A66 Northern Trans-Pennine Project

7.46 Applicant's Response to Deadline 7 Submissions

A66 Northern Trans-Pennine Project
Development Consent Order 202x

**7.46 APPLICANT'S RESPONSE TO DEADLINE 7
SUBMISSIONS**

C02	DC-19/25 Updates to layout and Classifications of Road				
	ASCO	ASCO	JJAS	DKID	SBAG
	04/05/23	04/05/23	04/05/23	04/05/23	04/05/23

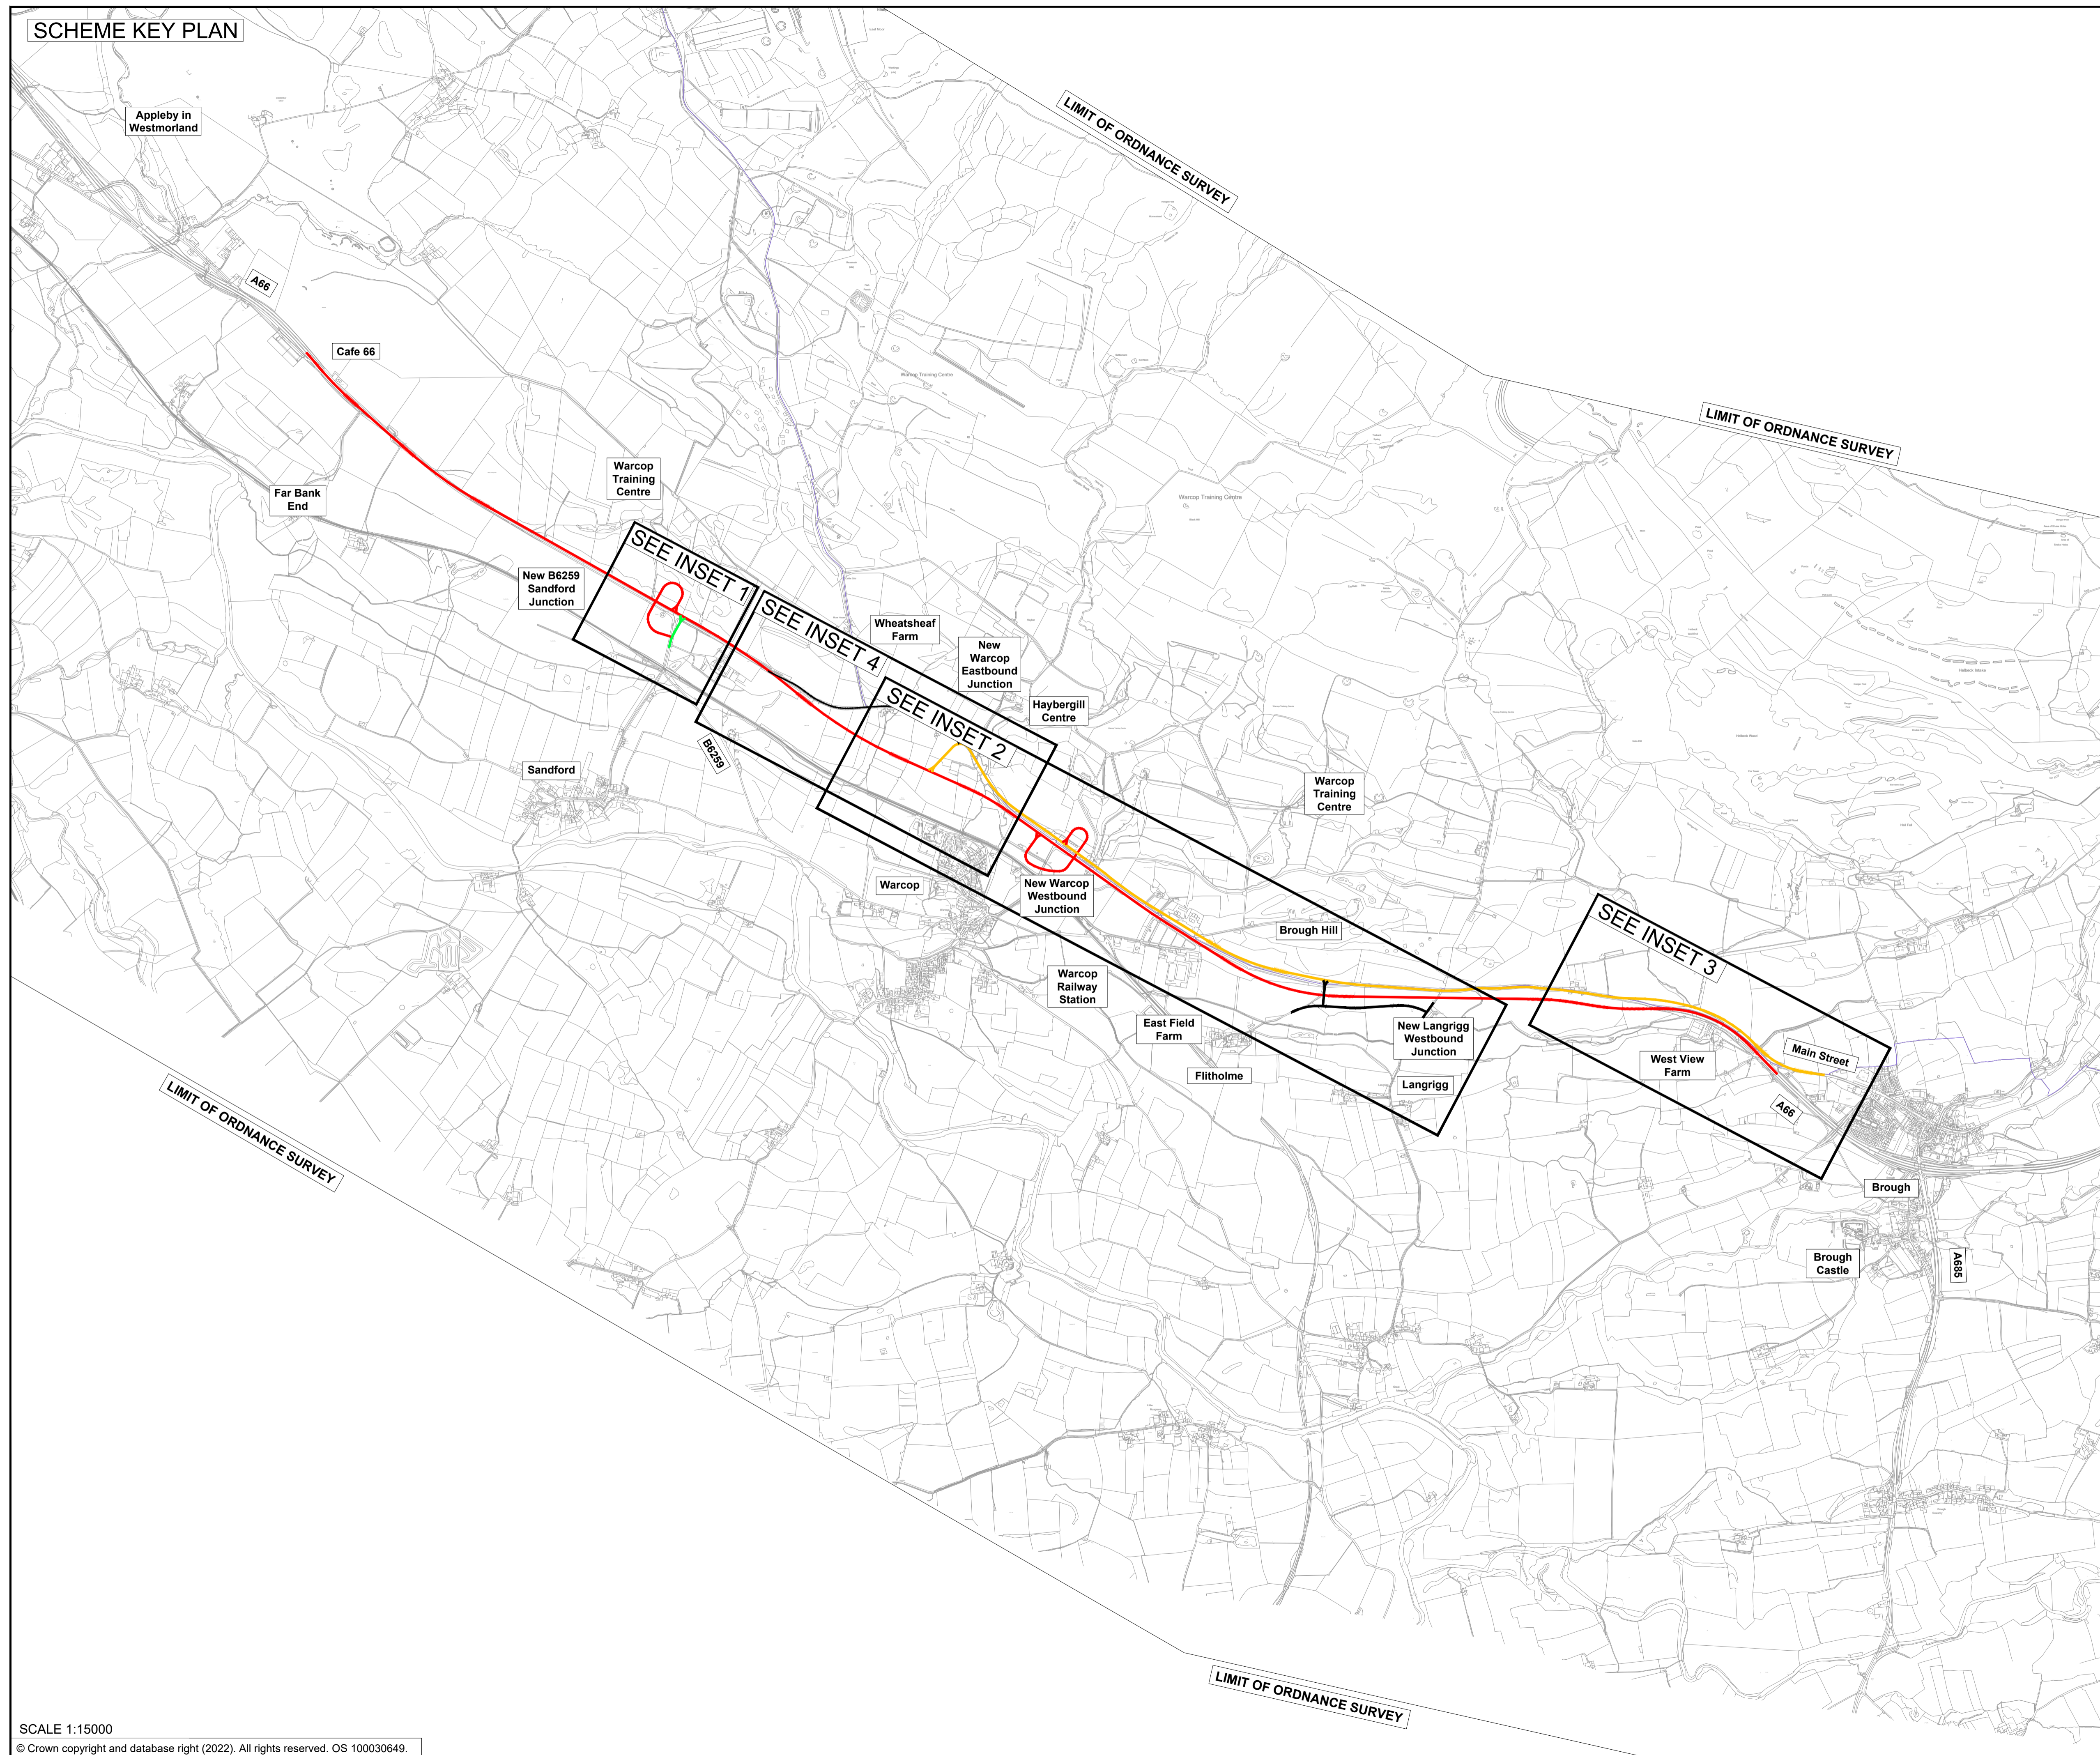
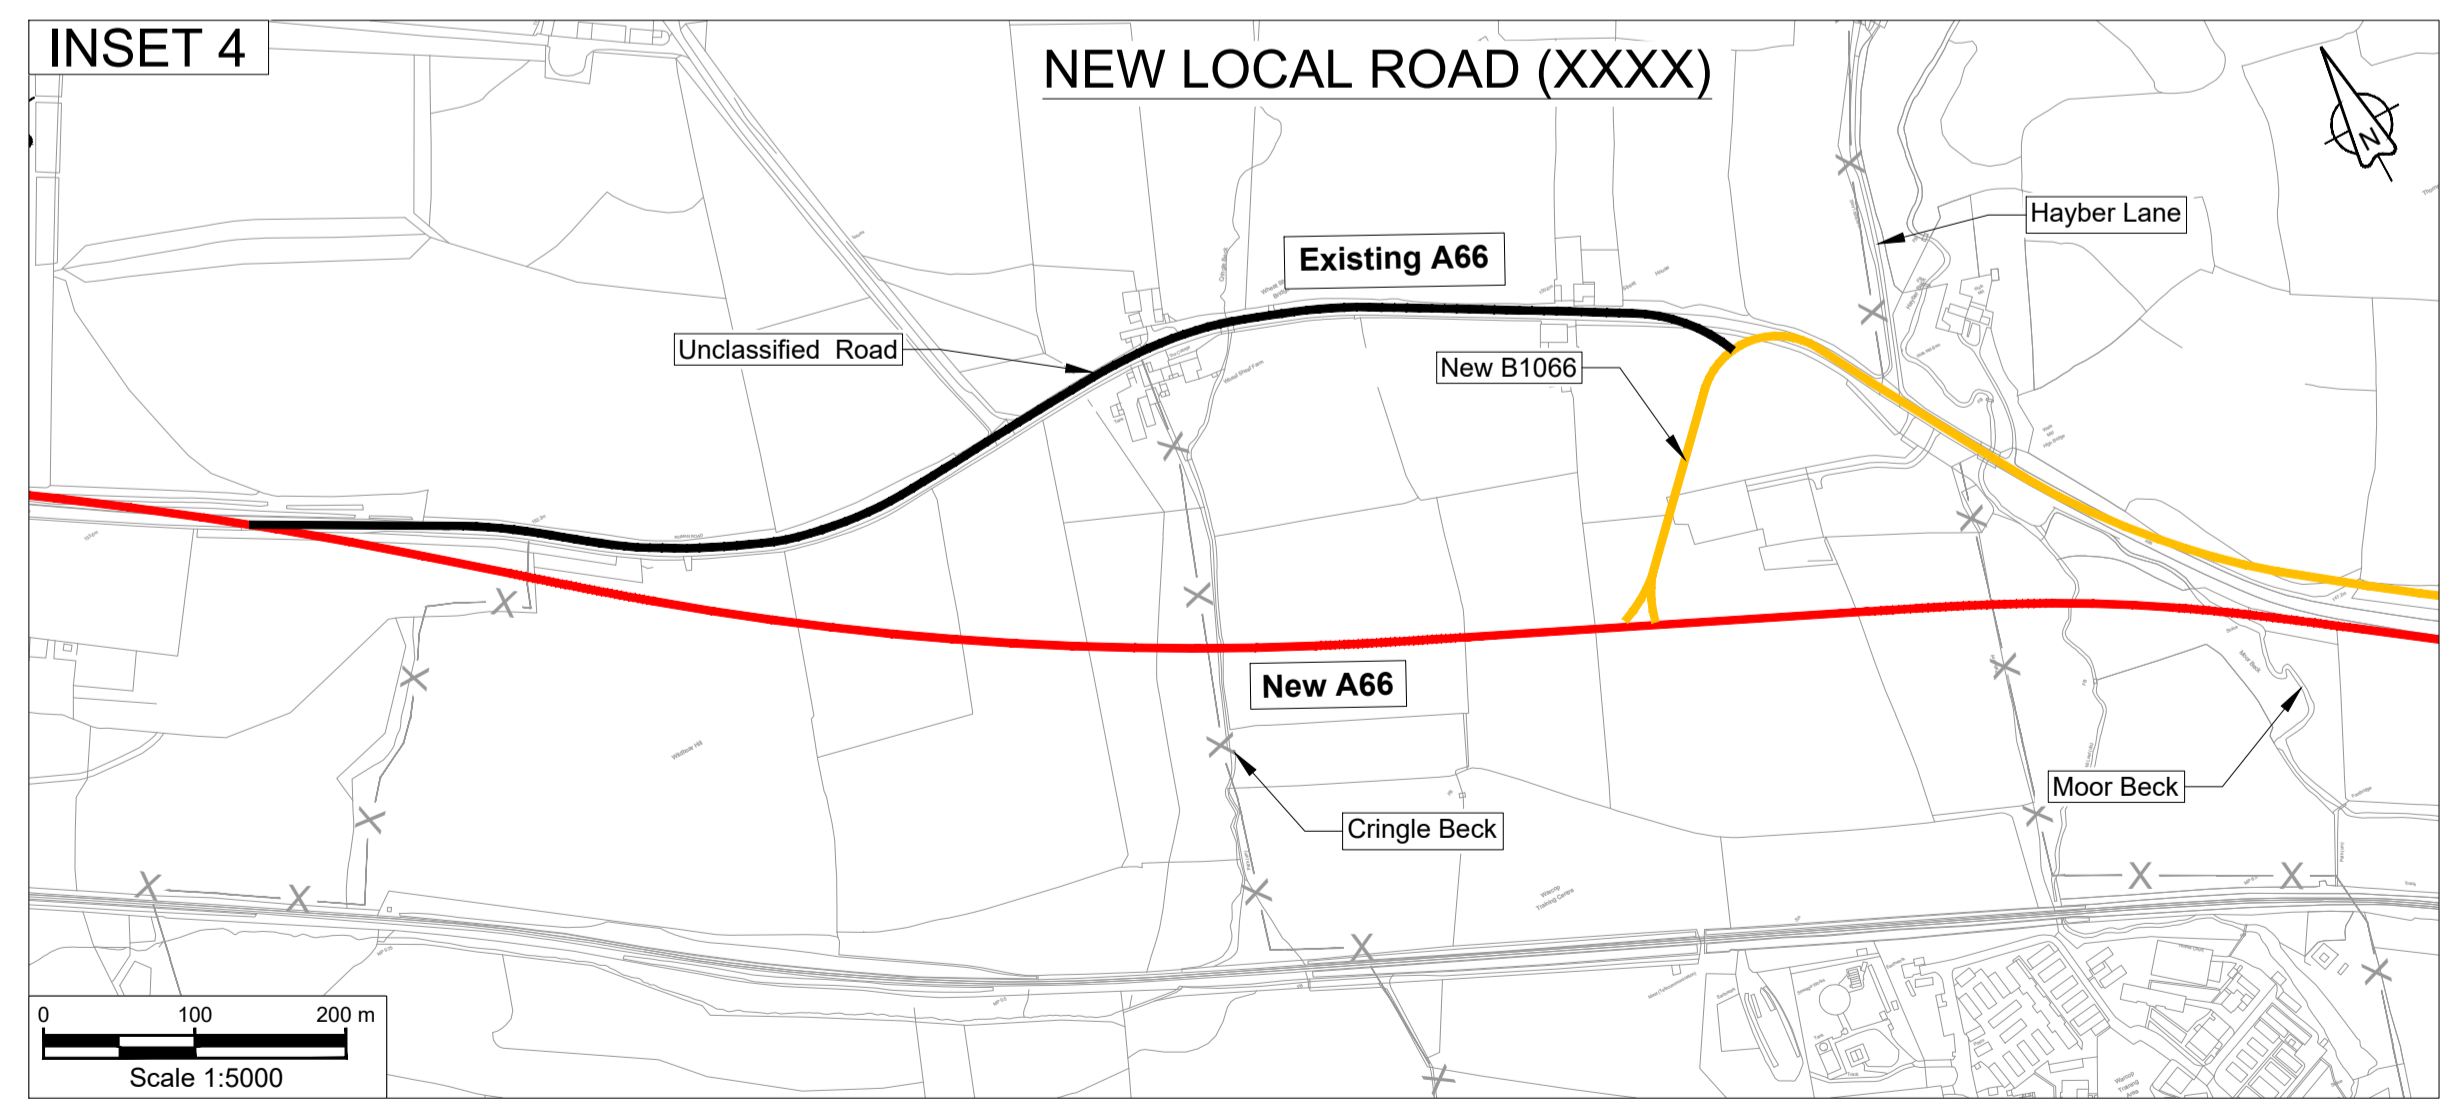
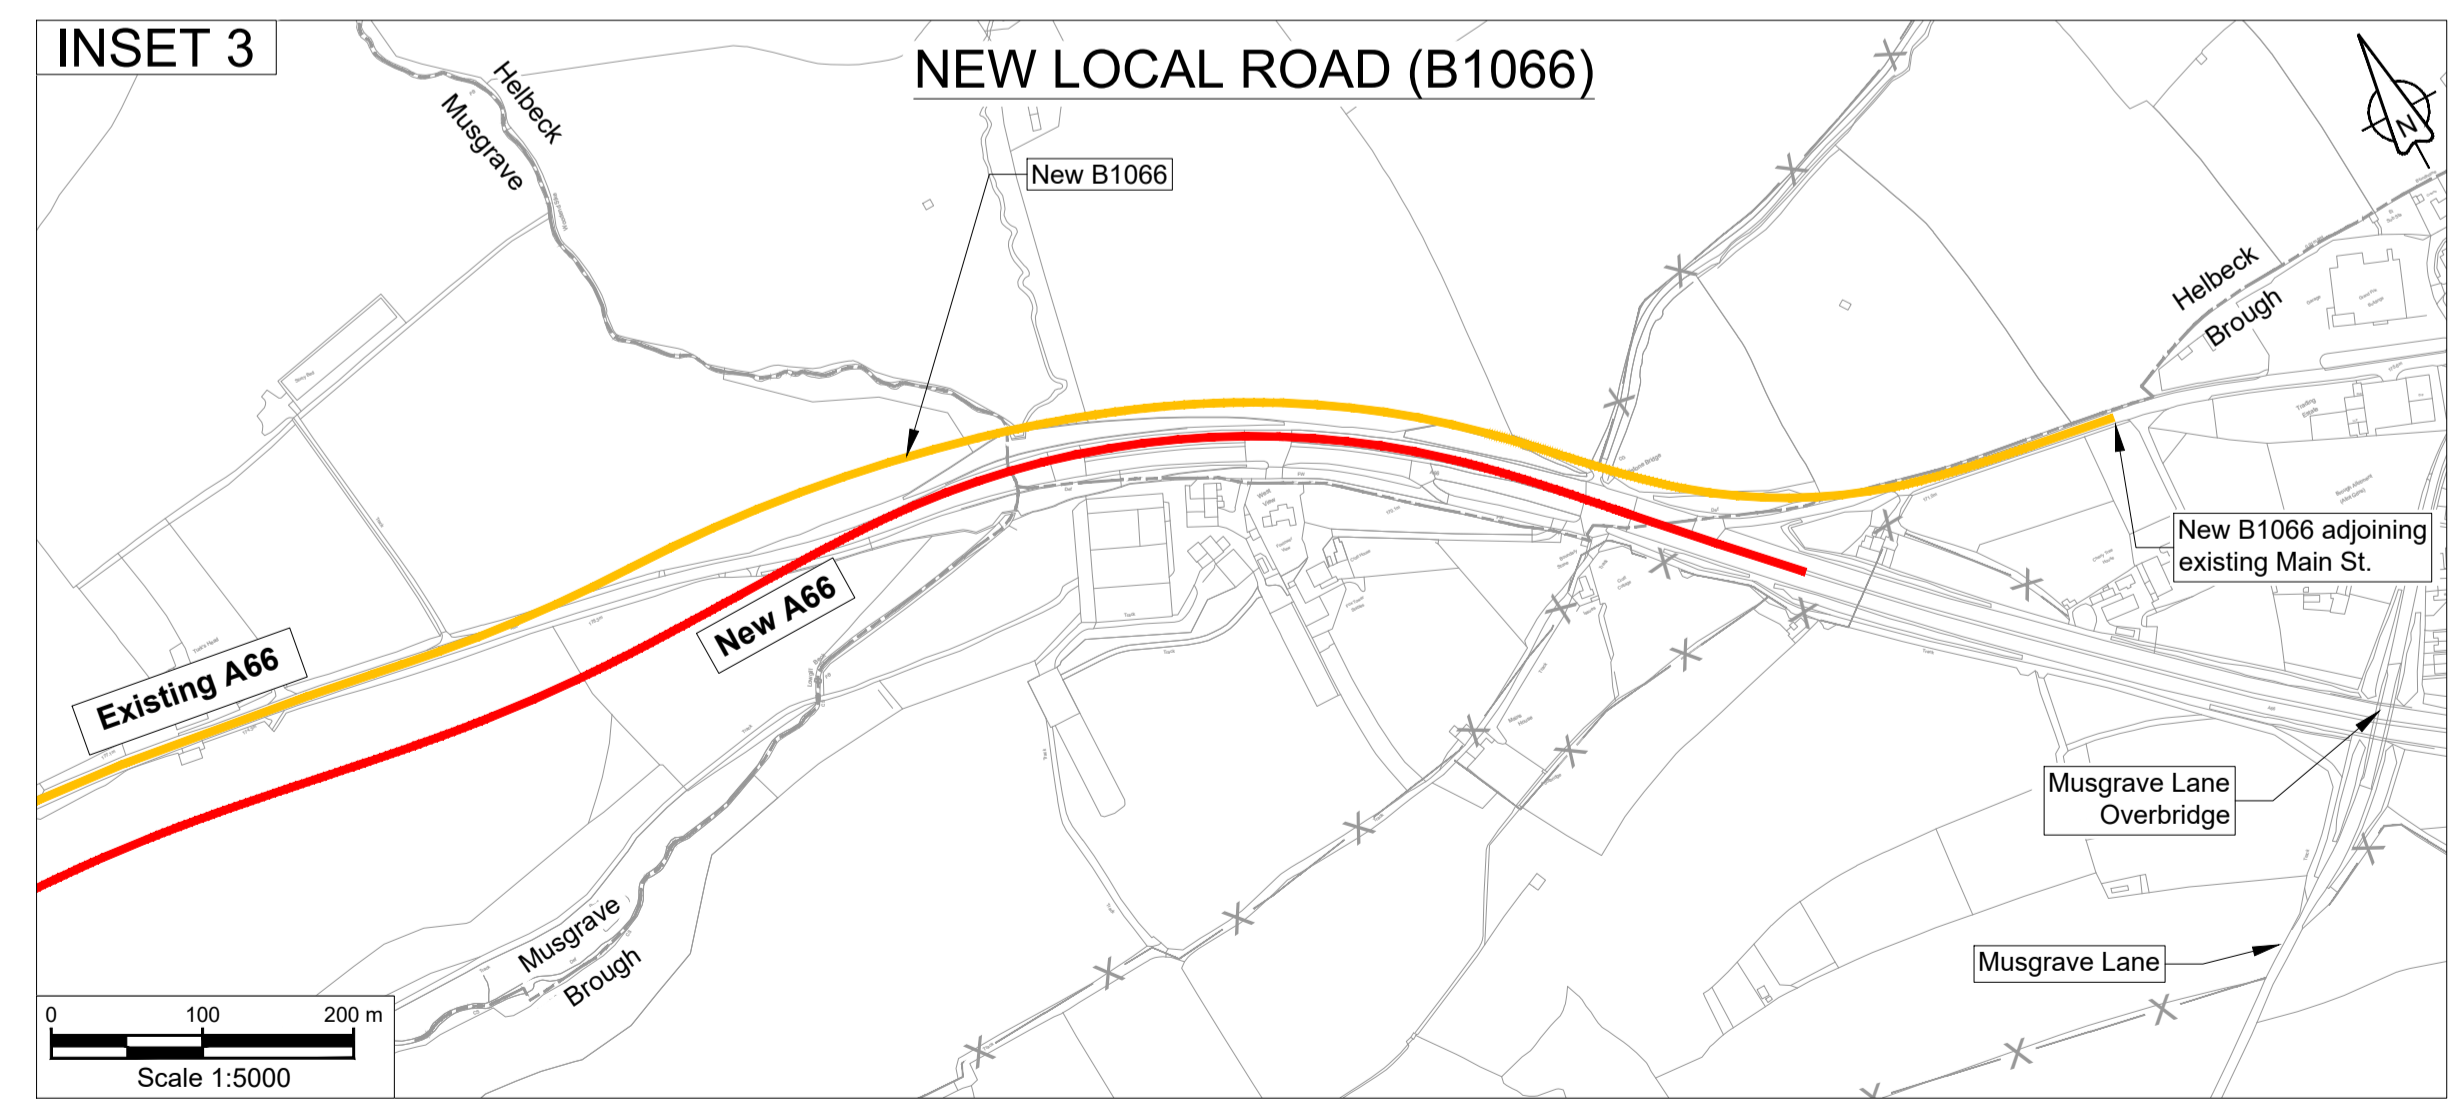
Examination Library Reference	Interested Party and Title of Submission	Issues Raised	Applicant's Response
		<p>DC-19 – Realignment of cycleway local to Cringle and Moor Beck</p> <p>Given that the proposed route will need to cross a 50mph road at a corner, the design will need to be amended to incorporate a safe crossing for non-motorised users. Compliance with LTN 1/20 crossing types is required (signals or grade-separation), given the likely speed and volume of traffic.</p> <p>DC-24 – Reuse of existing A66 (north of Flitholme)</p> <p>No further comments</p> <p>DC-26 - Revision to West View Farm accommodation bridge and removal of West View Farm underpass</p> <p>The Council is still concerned that overall connectivity for PRow users is not maintained.</p> <p>Latest plans clarify that the new bridleway (marked as 309/031) is retained with the changes.</p> <p>DC-27 – Construction of noise barrier south of Brough</p> <p>No further comments</p>
